Application No: AW/240/20/PL
Site Address: 17 Nyewood Lane Aldwick PO21 2QB
Description of works: Change of use of former residential parenting unit (C2 Residential Institution) to 8 bed House in Multiple Occupation (C4 Sui Generis). This site is in CIL Zone 4 (Zero Rated) as other development.

Planning Application AW/240/20/PL
House in Multiple Occupation - 17 Nyewood Lane, Aldwick

Plan Produced for: CHANGE OF USE APPLICATION

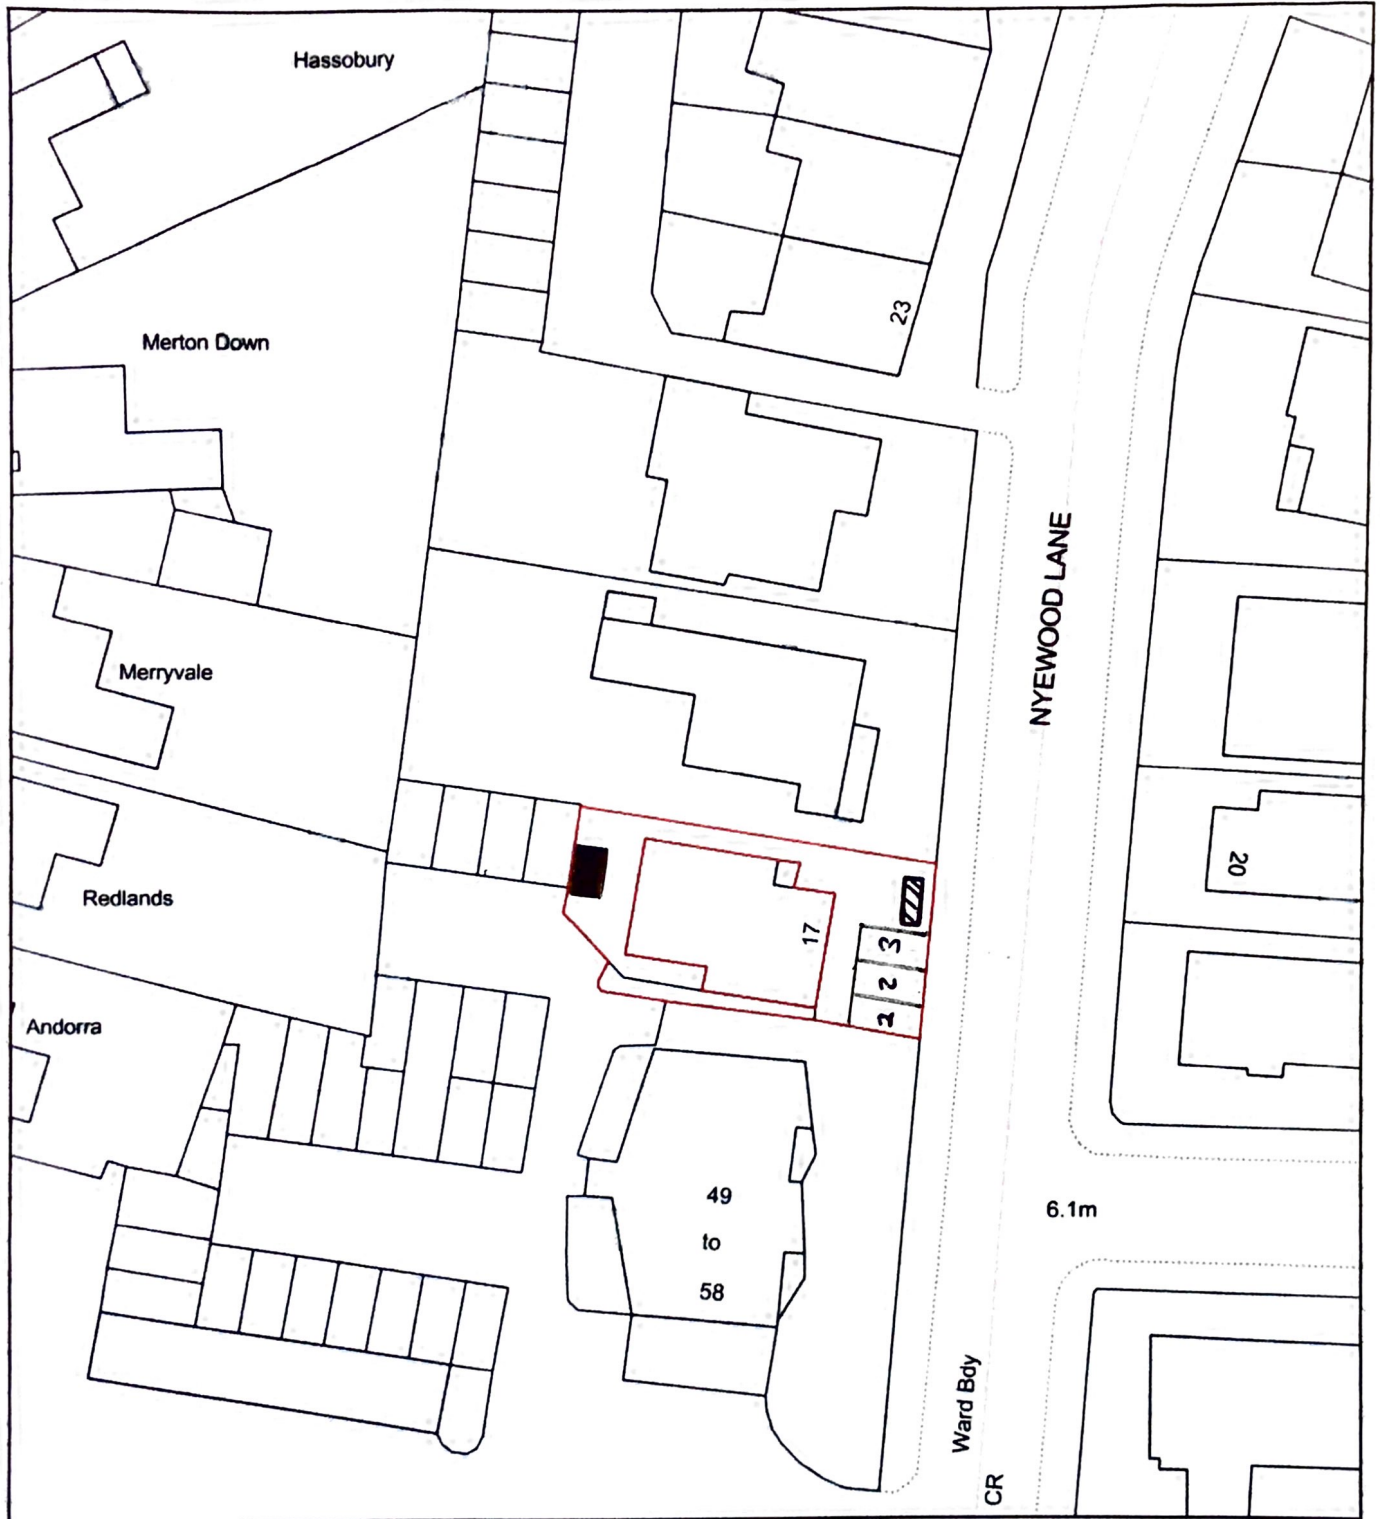
2. The proposal allows for three car parking spaces (in addition to refuse bin storage) at the front. This will result in the loss of one on-street parking bay. The consequence will be increased pressure on on-street car parking. Stocker Road is effectively parked up on both sides almost permanently. The roads behind the site (Wessex, Princess and Selsey Avenue) become fully parked by staff from local businesses and overflow parking from the Marine Park flats. Inevitably parking will become more contentious.

17 NYEWOOD
GROUND FLOOR
1:50 SCALE

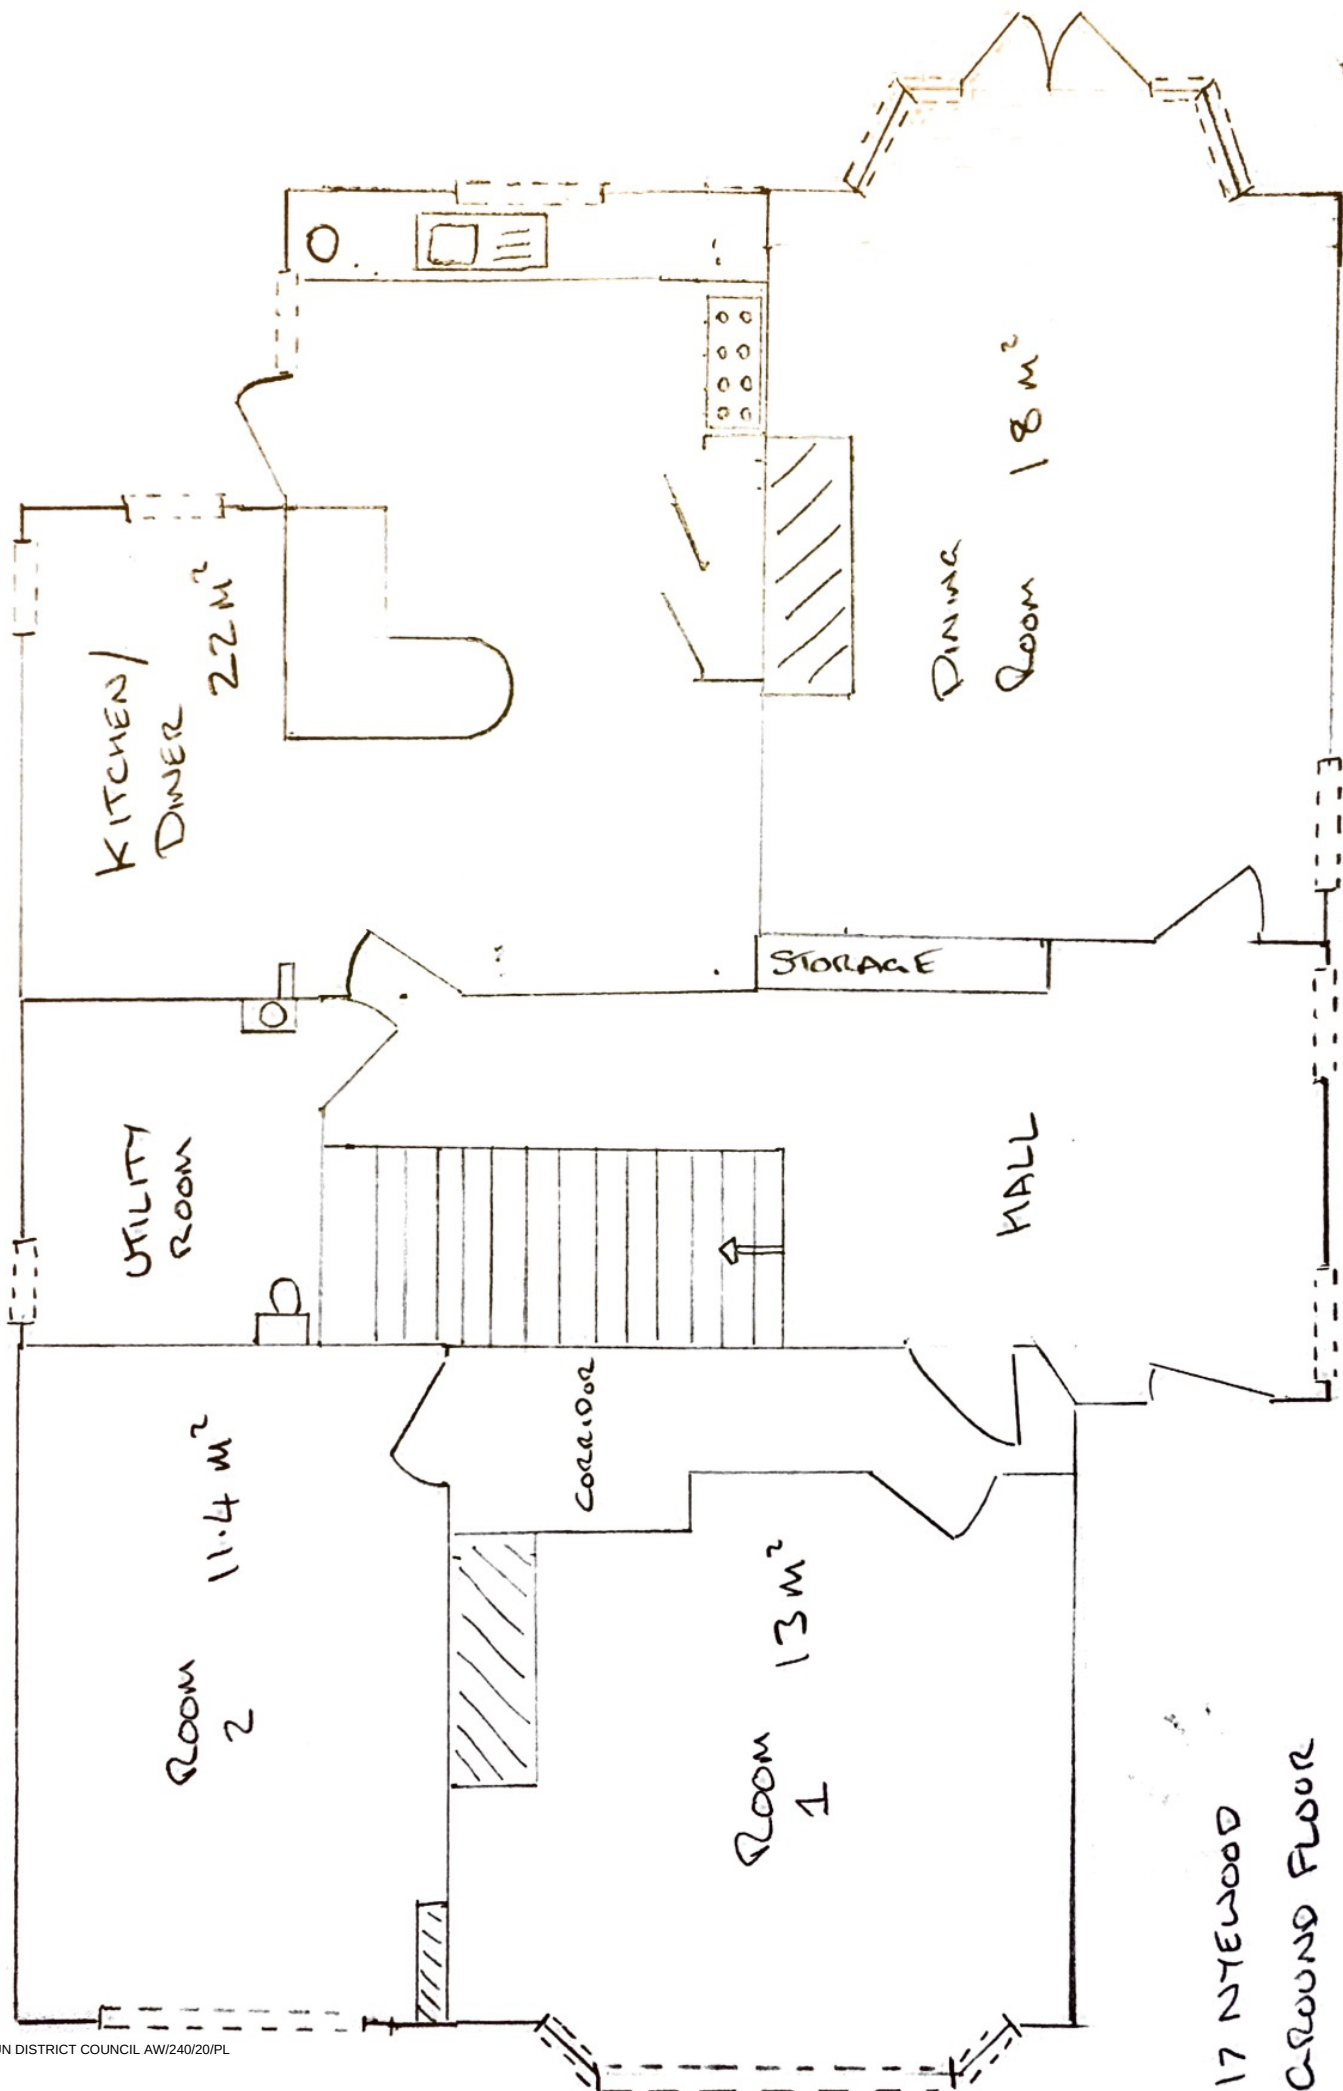
3. The plans do not show any fire escape other than the internal staircase (wooden?). Any external fire escape would have to be at the rear of the property and be intrusive for the properties along Wessex Avenue
